# Yorkshire Wildlife Trust

**Planning application:** Outline planning application for demolition of existing dwellings and development of phased, mixed use scheme comprising residential development (up to 1,354 dwellings), employment development (up to 35 hectares of B1(part a and c), B2, B8 uses), residential institution (C2) development (up to 1 hectare), a local centre (comprising A1/A2/A3/A4/A5/D1/D2 uses), a 2 form entry primary school including early years provision, green space, access and other associated infrastructure / Outline application for residential development (Use Class C3) of up to 181 dwellings, engineering and site works, demolition of existing property, landscaping, drainage and other associated infrastructure

**Location:** Land east of, Leeds Road, Chidswell, Shaw Cross, Dewsbury / Land south of, Heybeck Lane, Chidswell, Shaw Cross, Dewsbury

**Reference:** 2020/60/92331/E / 2020/60/92350/E

Client:	The Church Commissioners	Job No:	18,006
Project:	Chidswell Masterplan		
Title:	Parameter Plan - Access		
Date:	10/04/19	Scale:	As indicated
Drawing No:	00-205	Drawn By:	BBA1
		Checked by:	RG
		Revision:	E

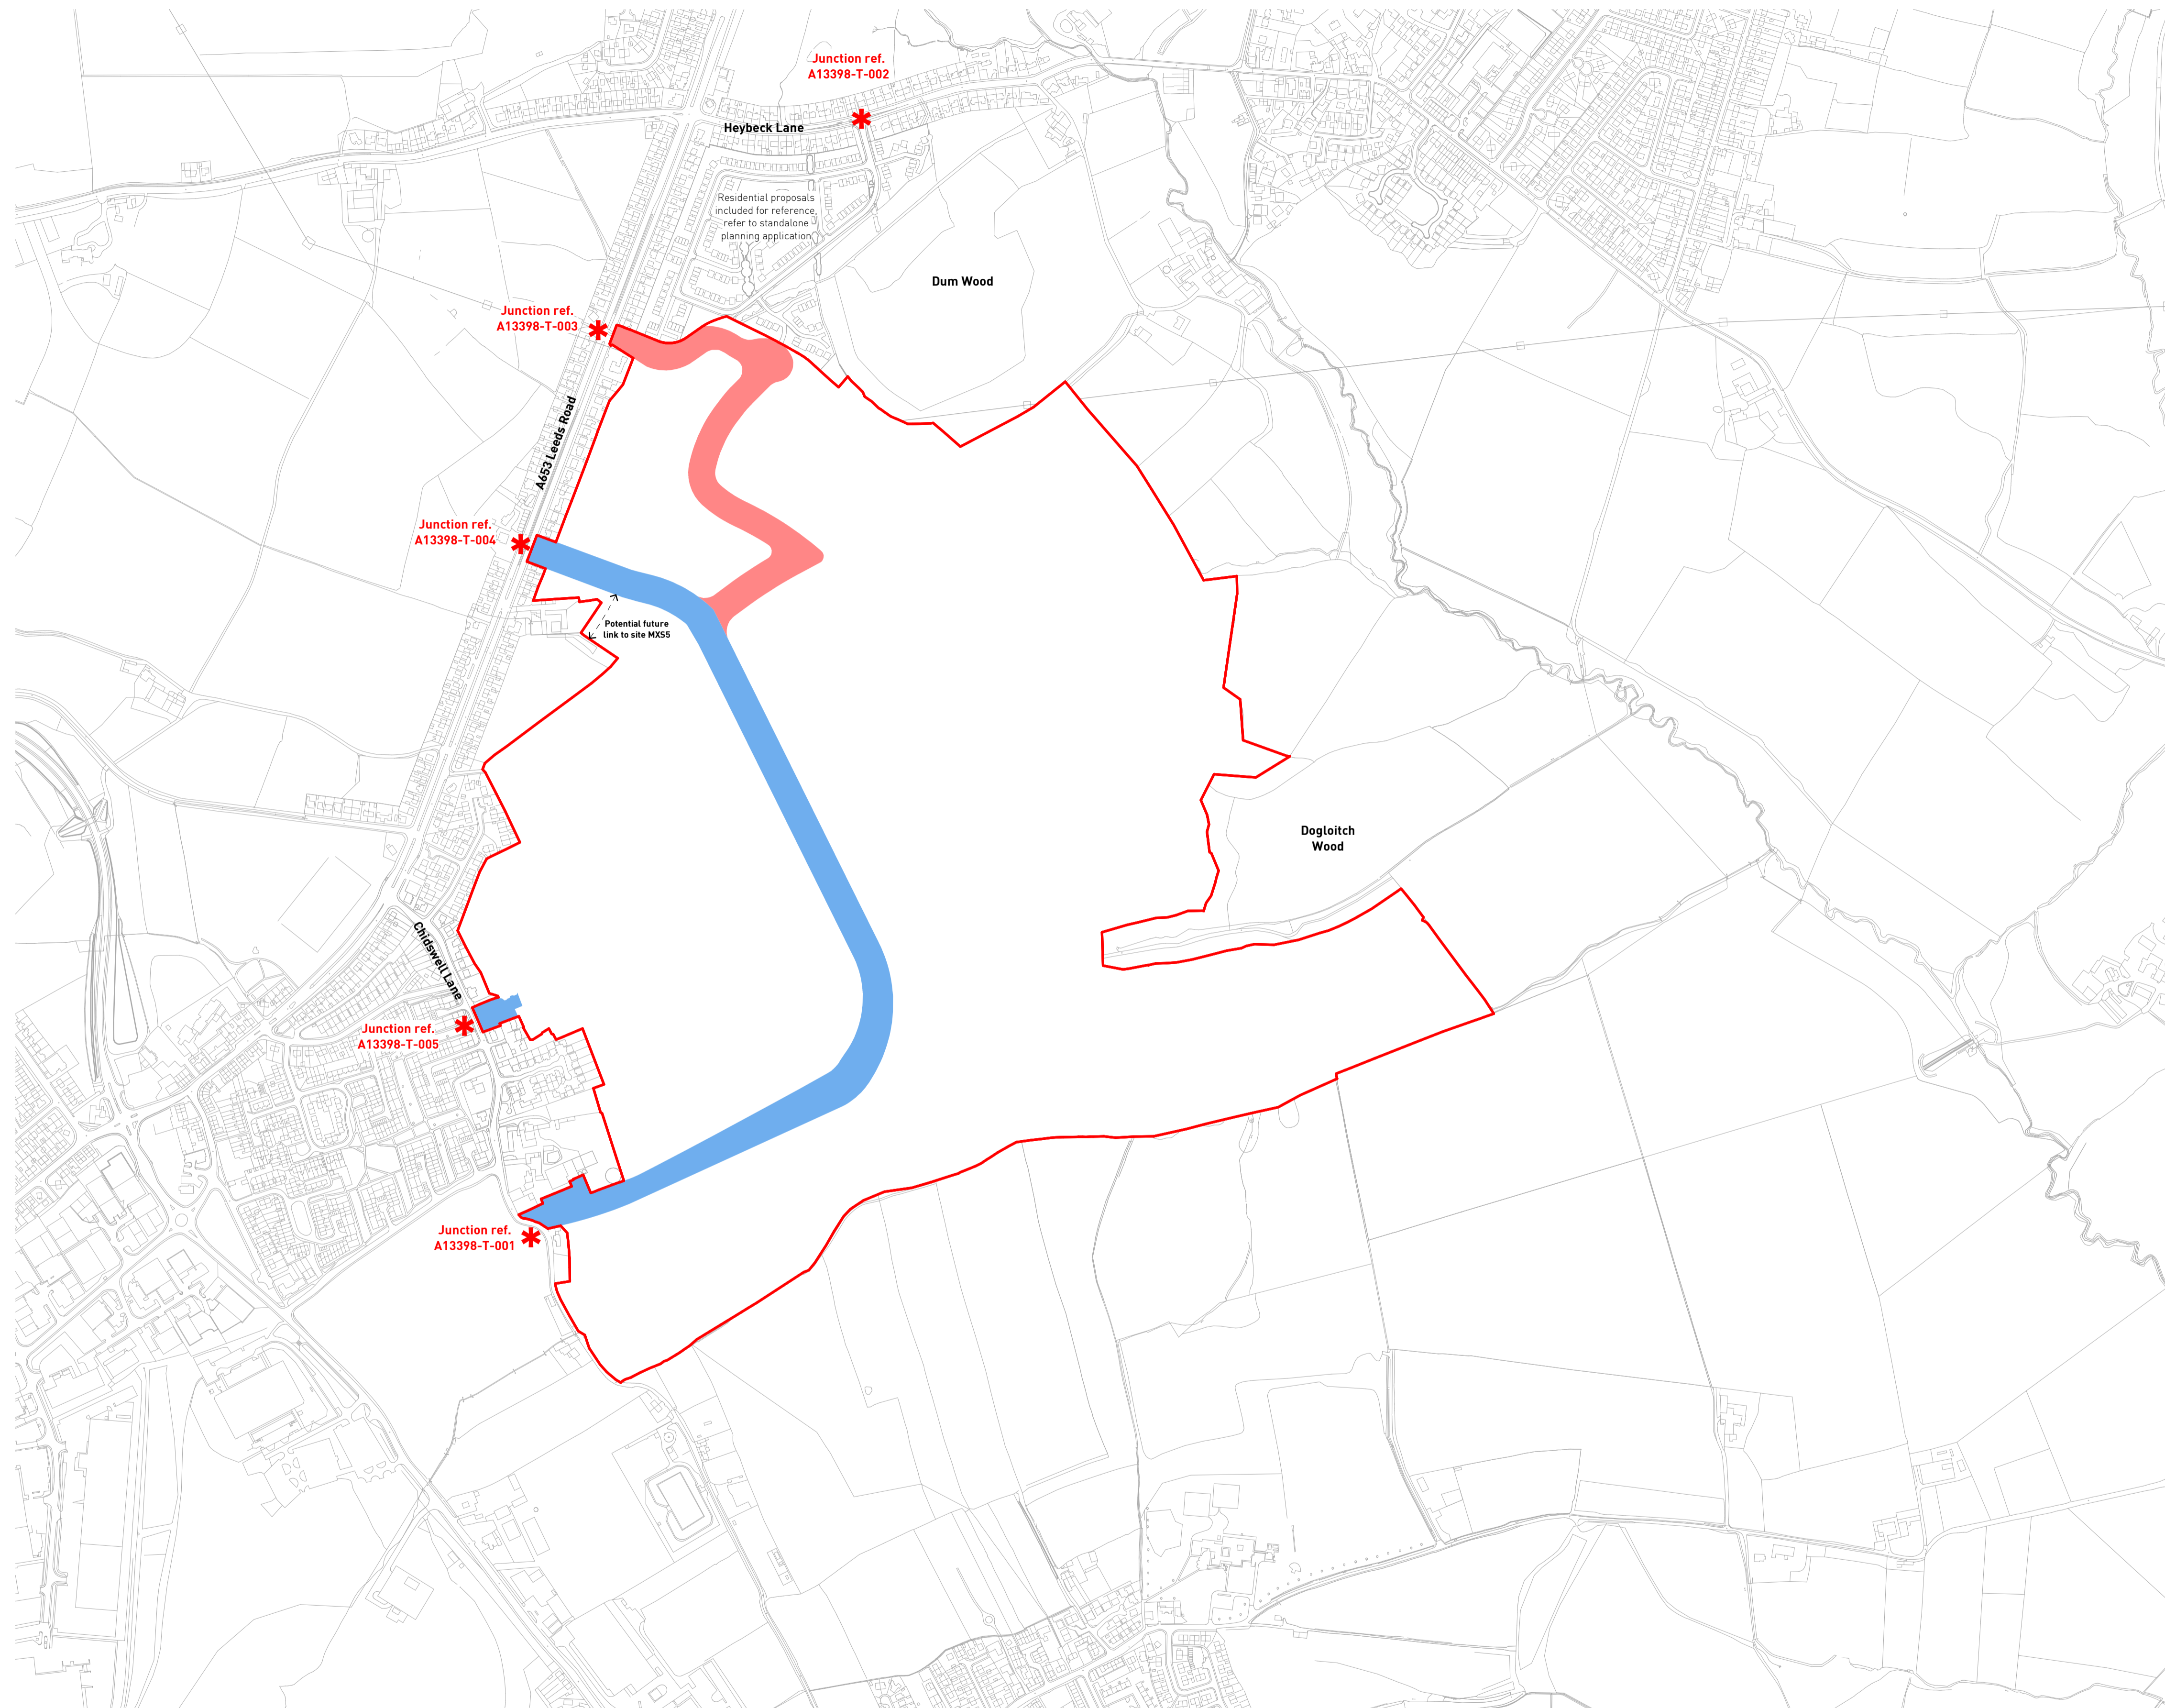
There has been an extensive suite of ecological surveys undertaken which have identified a number of constraints to the development. However, the recommendations to mitigate and compensate for these does not appear to have been included in the parameters plan at this stage. As such we would like to submit an objection to this application until such time as the design is refined and sufficient detail provided to ensure habitats and species have been appropriately mitigated/compensated and net gains for biodiversity can be achieved and maintained in perpetuity. This is in line with case law (see [here](#)) and [ODPM circular 06/2005](#) (para 99), which states that the LPA has a duty to consider impacts upon protected species prior to determination, and with NPPF para 175d and the emerging Environment Bill meaning a measurable net gain for biodiversity must be secured at the early stages of design.

Due to the importance of this site it is recommended that updated surveys, to include consideration for over-wintering, are conducted prior to determination and the parameters plan is revised to include above recommendations. The LPA must have careful consideration for the cumulative impacts of loss of farmland habitat upon these species within the local region.

In summary, we would like to submit an objection to this scheme at this time due to significant district level impacts upon breeding farmland bird species and potential significant district impacts upon LWS and KWHN. The current parameters plan has not taken into account ecological considerations or the recommendations made within the species reports and should be revised to incorporate these features whilst demonstrating a net gain of at least 10% for all habitat types. Careful consideration must be made by the LPA of cumulative impacts of this and other nearby developments upon sensitive habitats, species and ecological connectivity.

Client:	The Church Commissioners	Job No:	18,006
Project:	High Court Leeds		
	Chidswell Masterplan		
Title:	Parameter Plan - Blue Infrastructure		
Date:	03/09/19	Scale:	As indicated
		Checked by:	RG
Drawing No:	00-202	Drawn By:	DH
		Revision:	F

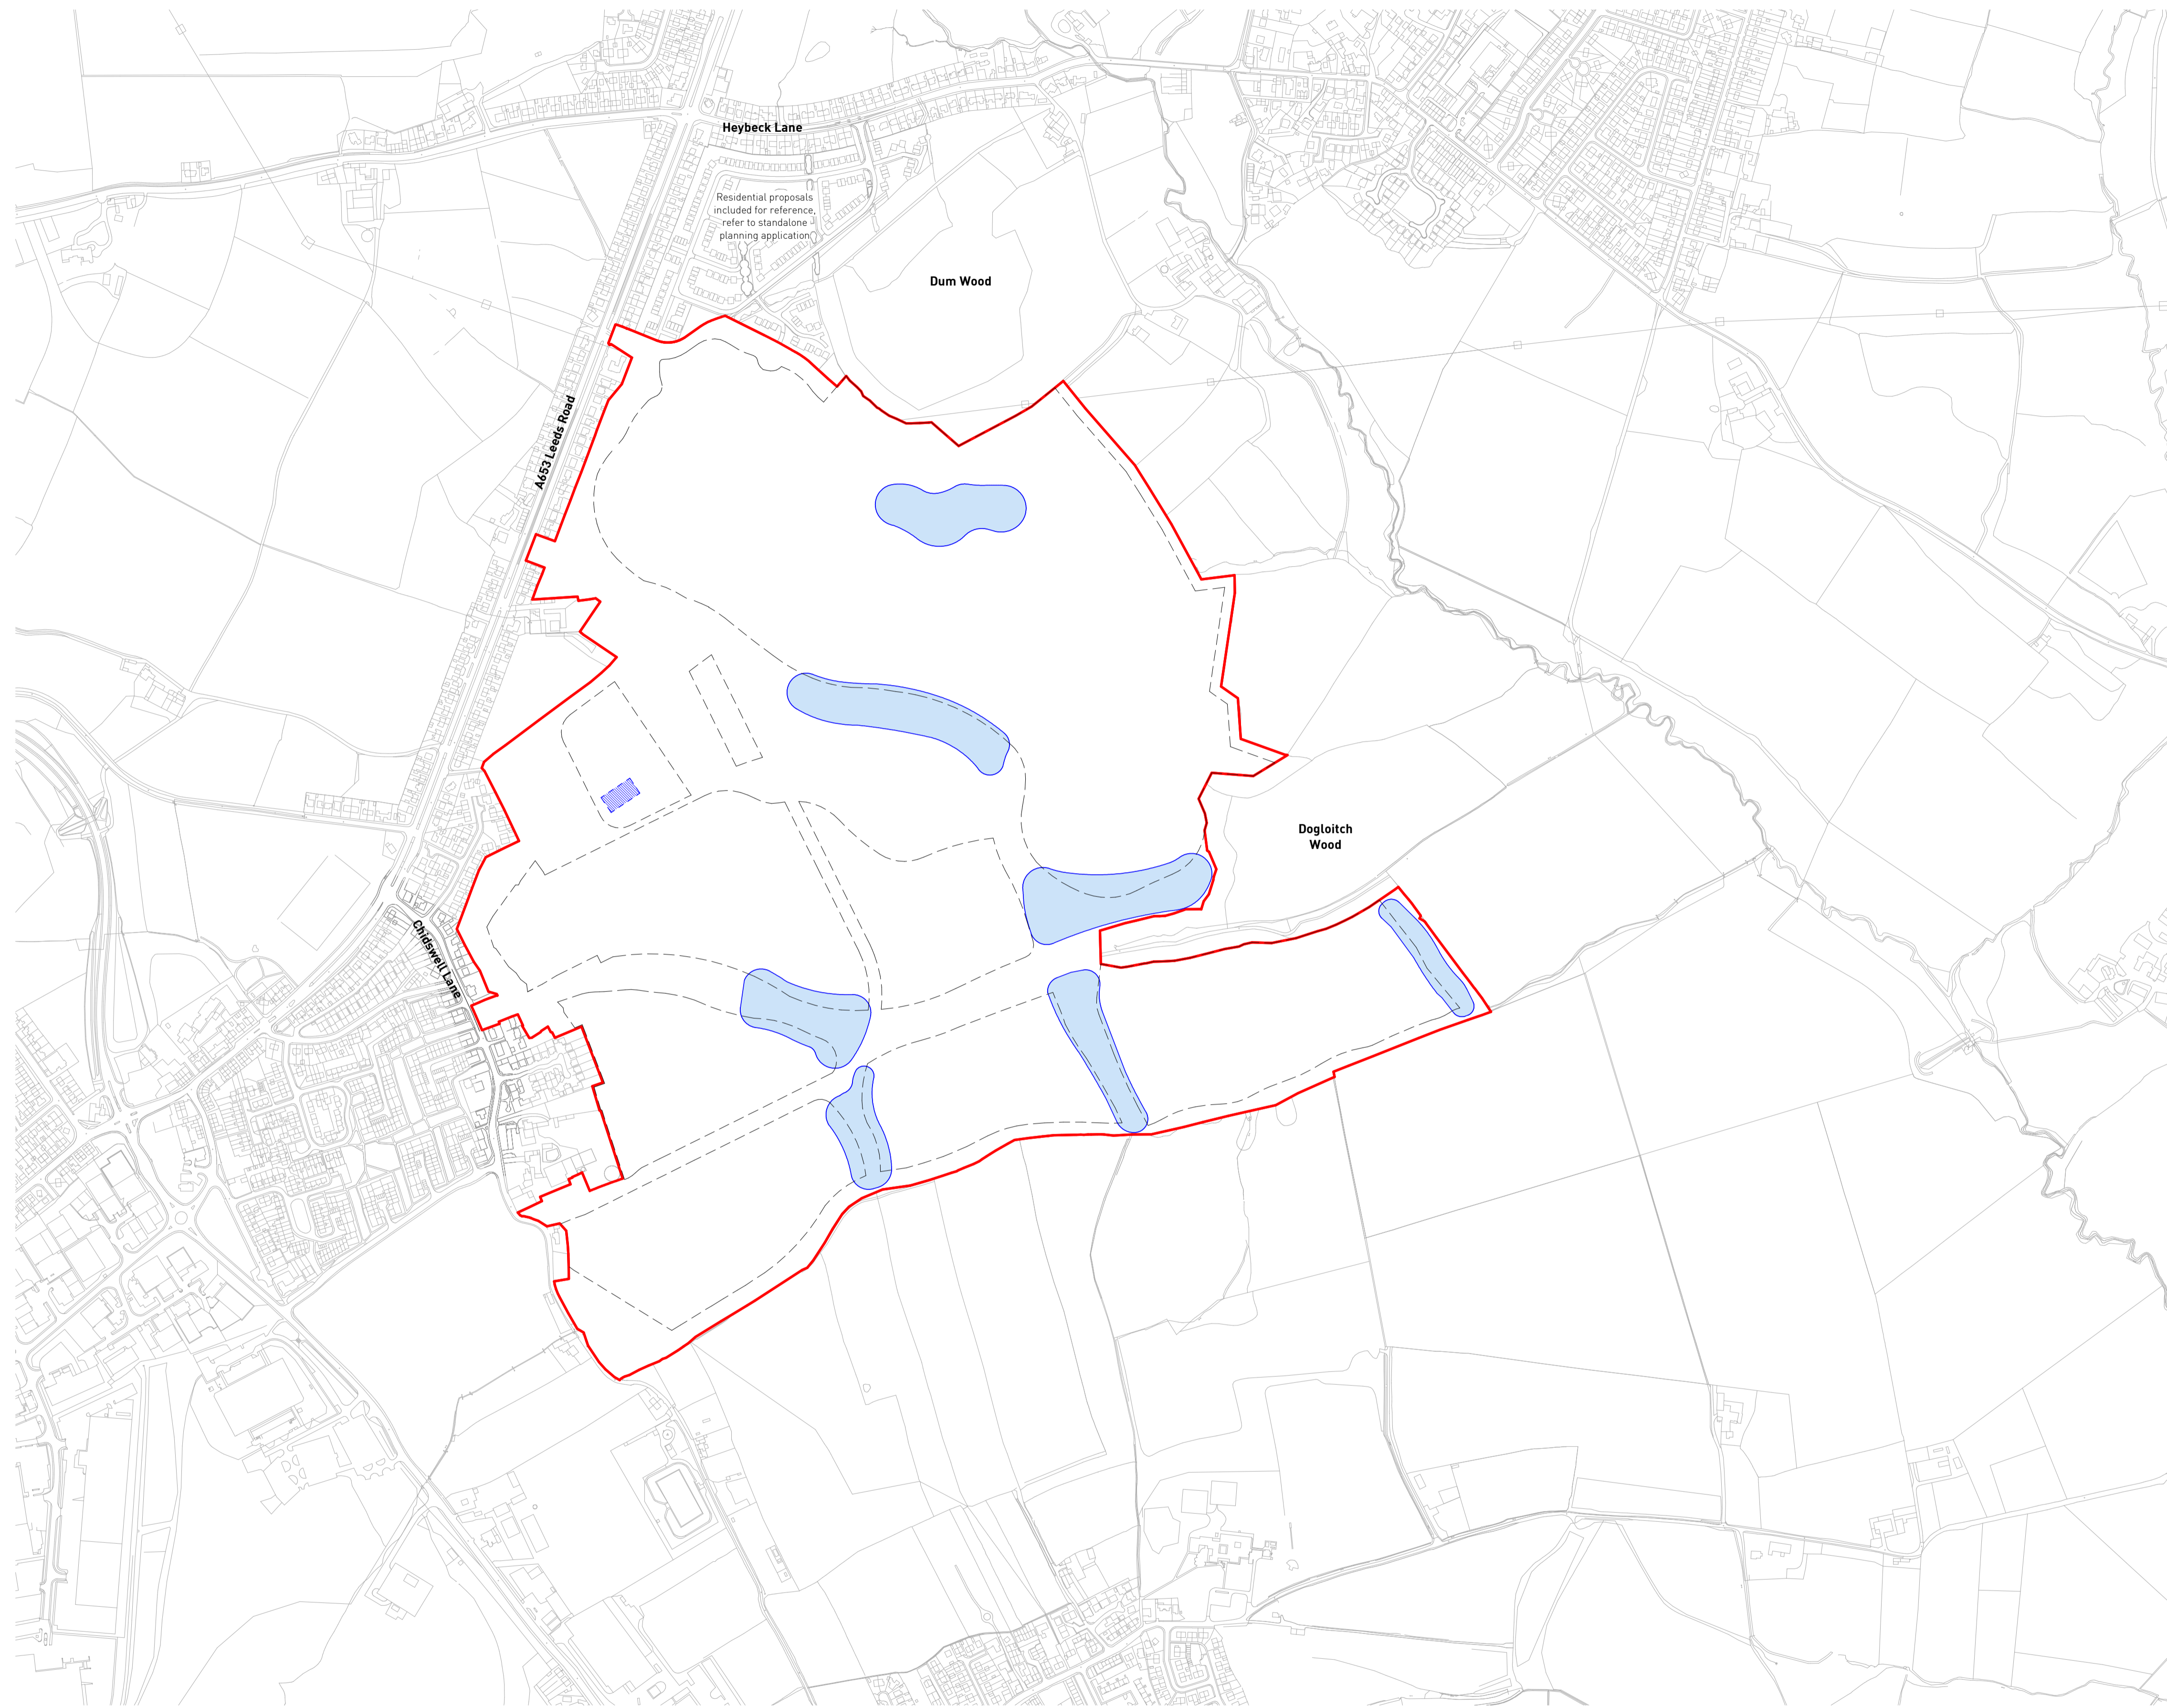
Areas of greenspace should be considered to deliver multifunctional benefits and we would recommend that the SuDS on site are also designed in this manner. Those principles outlined by Building with Nature<sup>1</sup> standards would be highly beneficial to incorporate within this scheme.

We would also suggest that allotments cannot reach '*moderate*' condition for the same reasons, giving a 12.58% net loss, and that whilst SuDs might be able to reach '*moderate*' condition if appropriately designed and managed this needs to be fully justified. Giving the current information provided including the statement in 14.120 (see below), it is implied that this will not be possible within the proposals and as such a precautionary approach giving a condition of '*poor*' for drainage features provides a **net loss of 14.29% for the scheme.**

We would welcome the provision of culvert design at an early stage to retain the openness of the watercourse for species such as water voles. Advice on how to design such culverts can be found in the Water Vole Mitigation Handbook (2016), which recommends, for instance, box culverts with >1m headroom above normal water levels with ledges immediately above the water level on both sides.
